From: Martyn White <Martyn.White@arun.gov.uk>
Sent: 17 January 2020 10:02
To: Zac Denton <Zac.Denton@arun.gov.uk>
Cc: Planning.Responses <Planning.Responses@arun.gov.uk>
Subject: AB/129/19/HH

AB/129/19/HH

Owl's Hoot is a 2 storey detached house, situated in the Arundel Conservation Area. There also a number of listed/locally listed buildings in the immediate area.

Proposed Extension and Alterations
at Owls Hoot, Arundel
for Mr R Dowson & Ms S Harnett
Drawing P02 October 2019 Scale 1:100 @ A3
Planning Drawing - Ground Floor & Roof Plan & Elevations

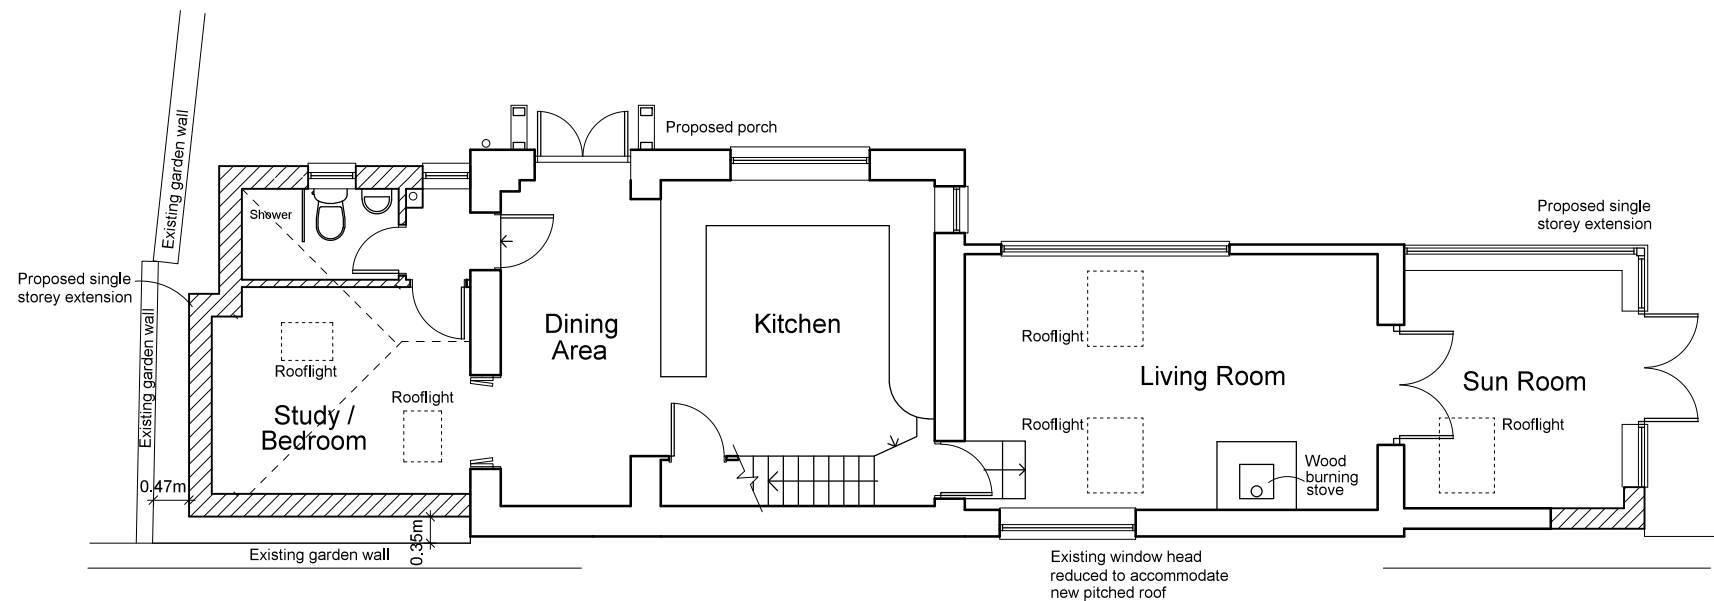
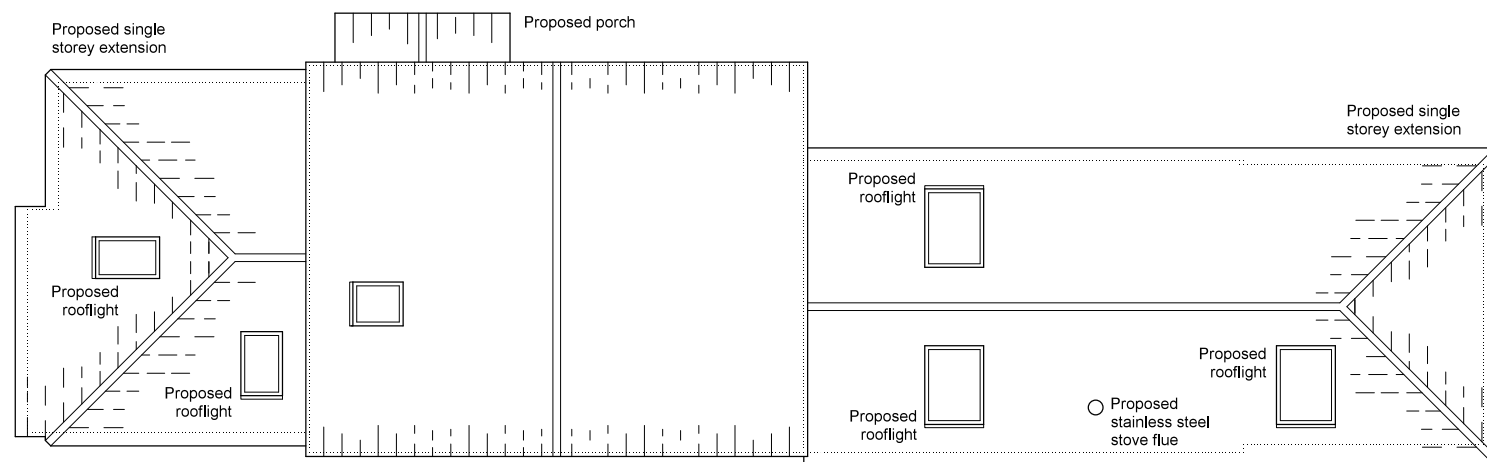
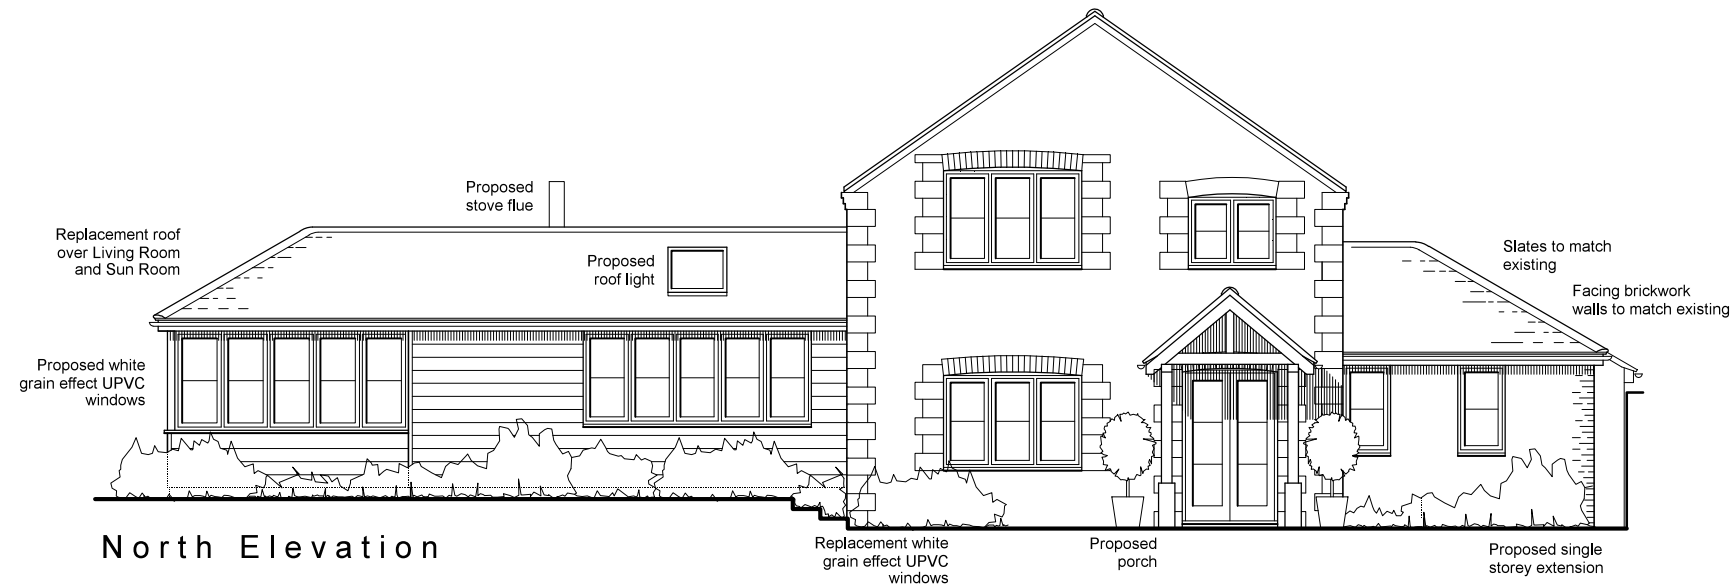
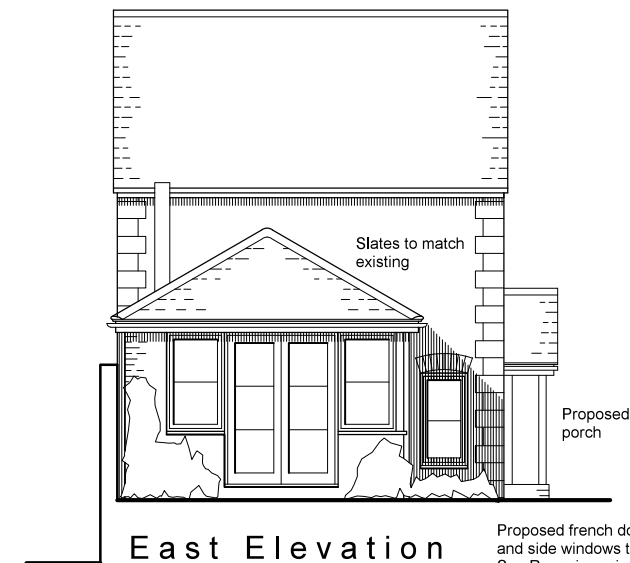
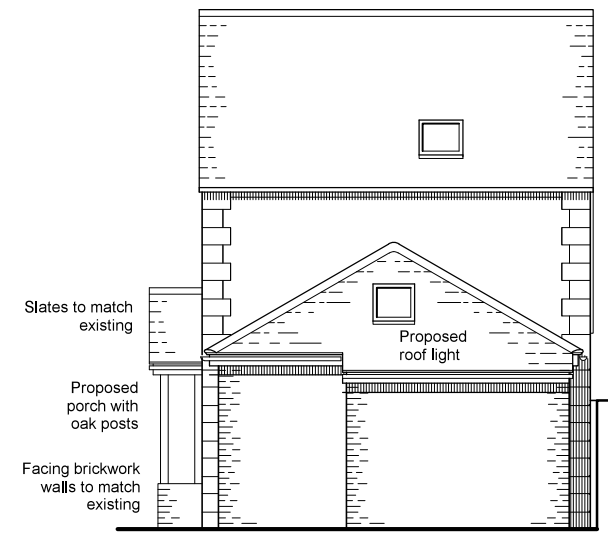
However, the proposed materials are problematic. They are not considered to be appropriate for both the existing, attractive older part of the dwelling, or the wider conservation area and other heritage assets. It is therefore suggested that more traditional materials are used as part of the proposal.

Therefore, if minded to approve the application, details of the joinery and materials should be provided to the council, by way of condition. This will allow the council to ensure that more appropriate materials are incorporated into the building. Likewise, all of the roof lights should be of conservation standard, with a vertical glazing bar.

At present, it is considered that the use of materials causes some harm to the building and the conservation area. This level of harm can be described as being on the lower end of less than substantial harm in accordance with paragraph 196 of the NPPF (2019). As such, you will also need to consider the public benefits that the development may achieve as part of your assessment of the application, along with the contents of the Planning (Listed Buildings and Conservation Areas) Act 1990 (as amended).
